Subject: RE: National Highways response: A/256/21/RES (layout amendments) - Land North of Water Lane, Angmering
Importance: High

Planning Application No: A/256/21/RES

Site: Land North of Water Lane, Angmering

Proposal: Approval of Reserved Matters following outline consent A/248/21/PL for the erection of 525 No residential dwellings with associated parking, landscape, play areas & public open space (amendments to the layout).

Northern boundary buffer

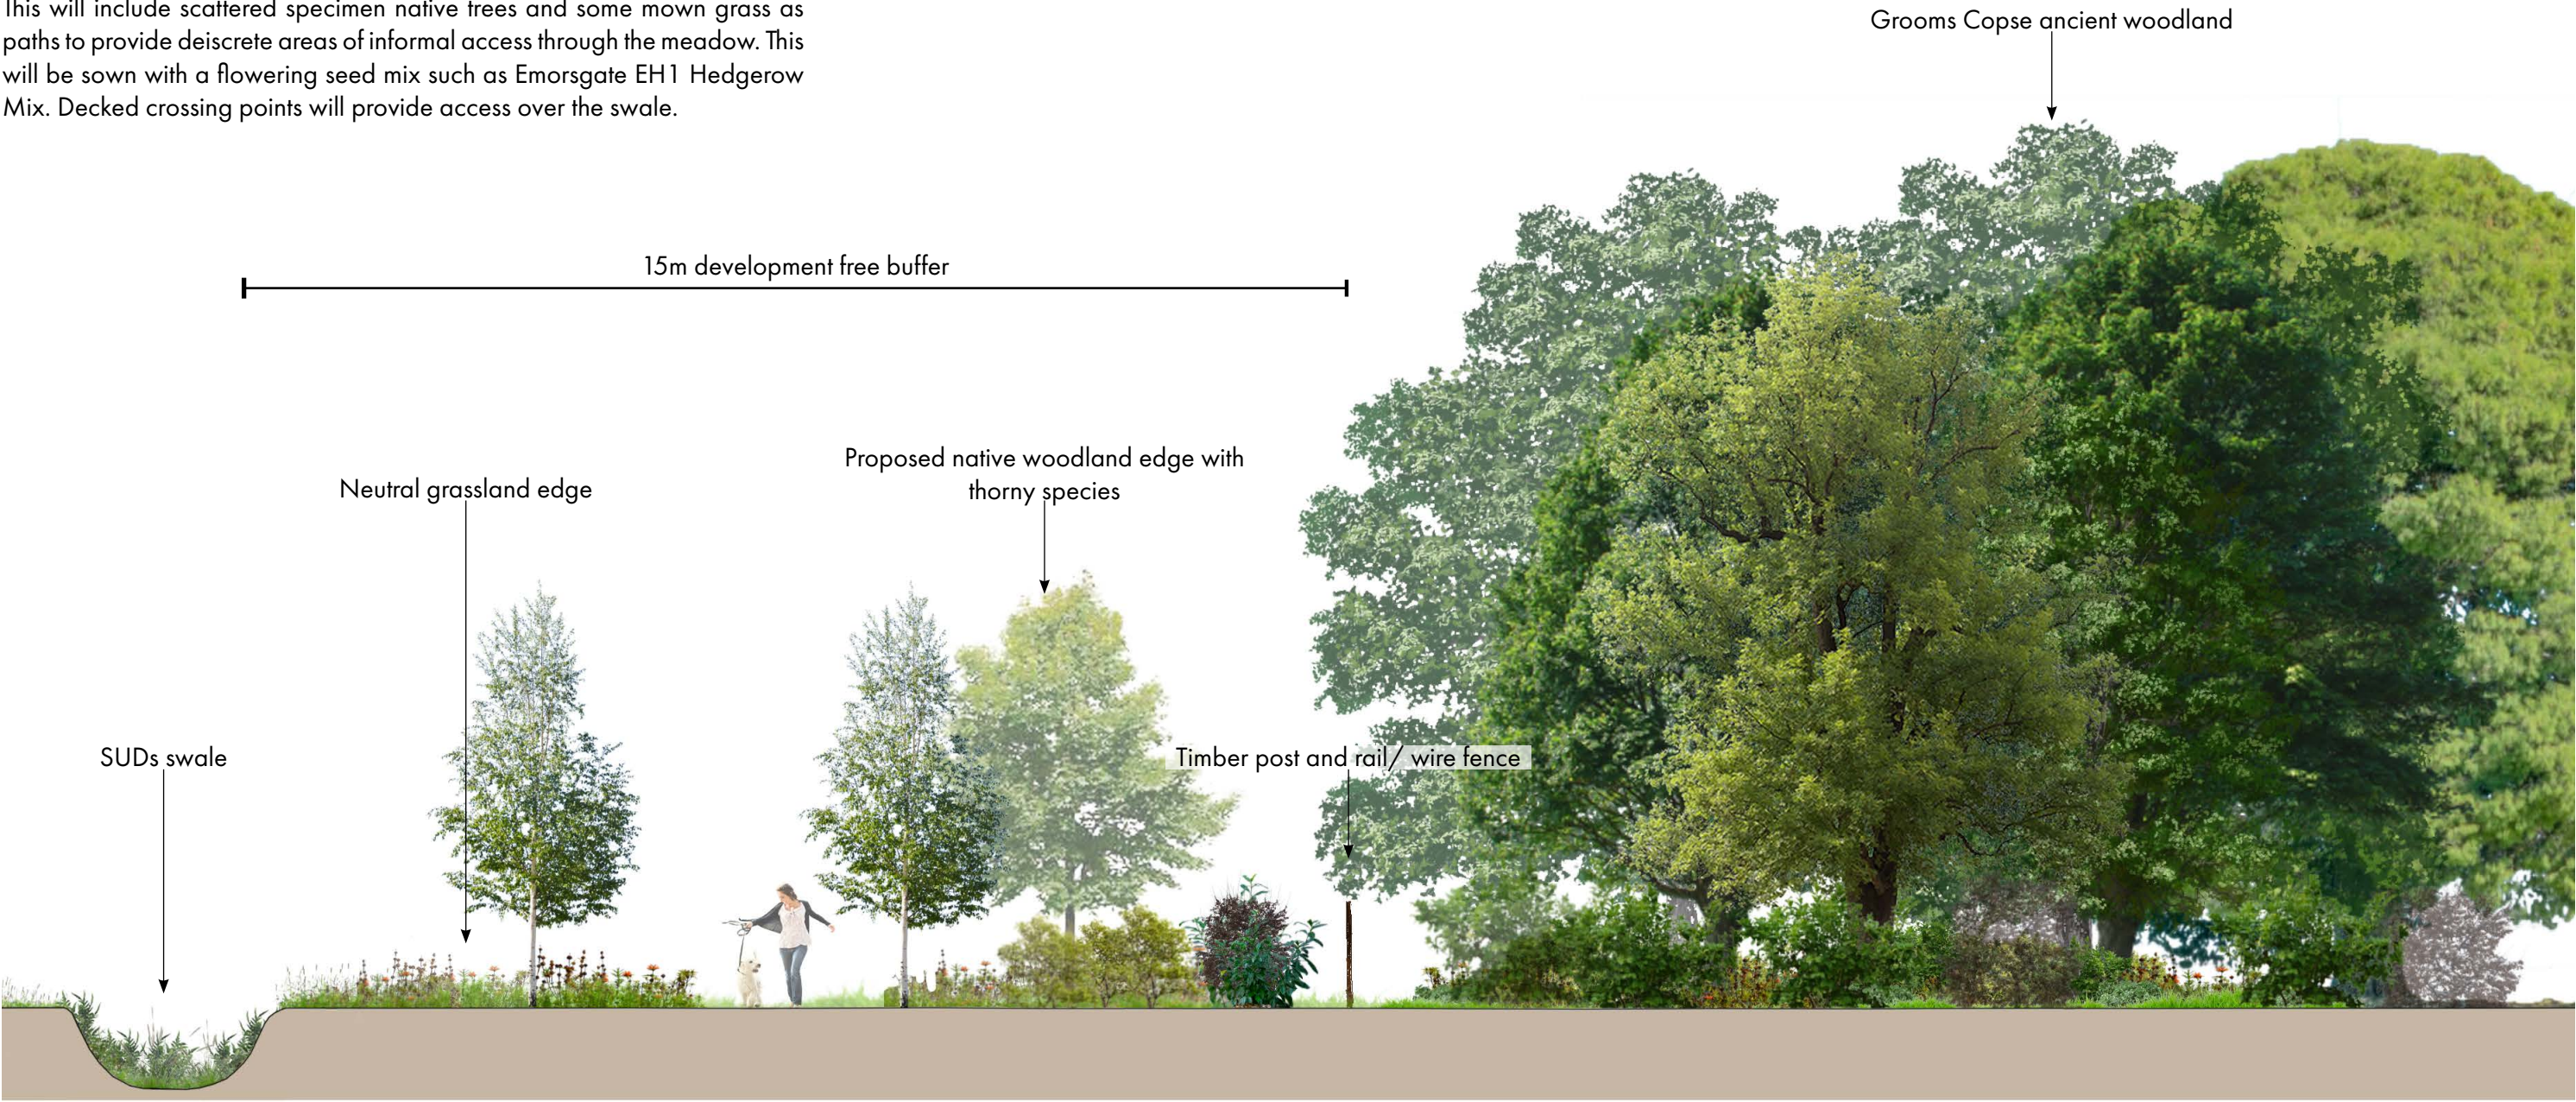
We note that the amendments include a proposed landscaped bund along the northern boundary with the A27 and a proposed fence along the A27 highway boundary. We require further information from the applicant regarding these proposed revisions to the reserved matters application in order to fully assess the implications on the safety and operation of the A27. In particular, the following comments should be passed on to the applicant:

The proposed earthwork would present a geotechnical risk and consequently the applicant must follow the requirements of Design Manual for Roads and Bridges standard CD622 'Managing geotechnical risk'. Accordingly further information is required to ensure any land and construction work adjacent to the A27 embankments are constructed in a way that projects the integrity of the A27.

Action: Applicant to provide the information as required by Design Manual for Roads and Bridges standard CD622 '*Managing geotechnical risk*'. The first requirement is a Statement of Intent which demonstrates the risks and the proposals to manage it and sets out the other reporting requirements proposed for National Highways to agree.

Further information is required to assess how the drainage would be affected by the bund, both from runoff from the slope facing the A27 and the potential for the bund to act as a dam and prevent flow away from the A27. To inform this assessment, the applicant must provide the latest site specific Flood Risk Assessment Report and provide details of onsite drainage arrangements across the landscape bund, including surfacing materials and levels to demonstrate that no surface water runoff will discharge on to the SRN or into the carriageway drainage systems or that the landscape bund will not prevent drainage from the SRN into the Site. As part of this package of information a cross section of the landscaped bund with the proposed dimensions and levels specified to ensure that no flooding will occur on the A27 and that the existing drainage will not be affected by new development. The required information for the cross section is shown in yellow annotations on the cross section in Figure 1 below.

ACTION: The applicant to provide details of onsite drainage arrangements across the landscape bund, including surfacing materials and levels to demonstrate that no surface water runoff will discharge on to the SRN or into the carriageway drainage systems or that the landscape bund will not prevent drainage from the SRN into the Site. This should include a cross section including proposed levels of the peak and trough of the landscape bund and detail on how the surface run-off of the bund will be managed within the development site boundary.

ACTION: The applicant must advise on the mitigation measures to ensure that the existing drainage along the A27 (Westbound) carriageway is protected while groundwork and

erection of a bund is undertaken. Root protection must also be assessed given the trees proposed to be planted in proximity of existing drainage channels.

ACTION: It should be confirmed that the fence is designed in accordance with the Manual of Contract Documents for Highway Works (MCHW) series 300. We require detail on the precise location for the fence and how it will be constructed and maintained without the need to enter onto highway land.

ACTION: In view of the proximity of the proposed fence to high speed traffic on the A27 carriageway, it will need to be subject to the Road Restraint Risk Assessment Process in accordance with the standards set out in the Design Manual for Road and Bridges CD 377.

1. Prior to the occupation of 150 dwellings on the site hereby permitted details of the geotechnical arrangements for the bund along the northern boundary with the A27 shall be submitted to and approved in writing by the Local Planning Authority. This shall include details of all materials, levels and calculations to demonstrate that the bund is geotechnically stable in accordance Design Manual for Road and Bridges CD622. The bund shall be implemented prior to the occupation of 400 dwellings in accordance with the details so approved.

2. Prior to the occupation of 150 dwellings on the site hereby permitted details of the drainage arrangements for the bund along the northern boundary with the A27 shall be submitted to and approved in writing by the Local Planning Authority. This shall include details of the surfacing materials and levels to demonstrate that no surface water runoff will discharge onto the A27, either during construction or post implementation.

3. Prior to first occupation details of the fence to be erected along the northern site boundary with the A27 shall be submitted to and approved in writing by the Local Planning Authority. This shall include details of its location, materials, height and maintenance arrangements, which shall be in accordance with the Manual of Contract Documents for Highway Works (MCHW) series 300 and Design Manual for Road and Bridges CD377.
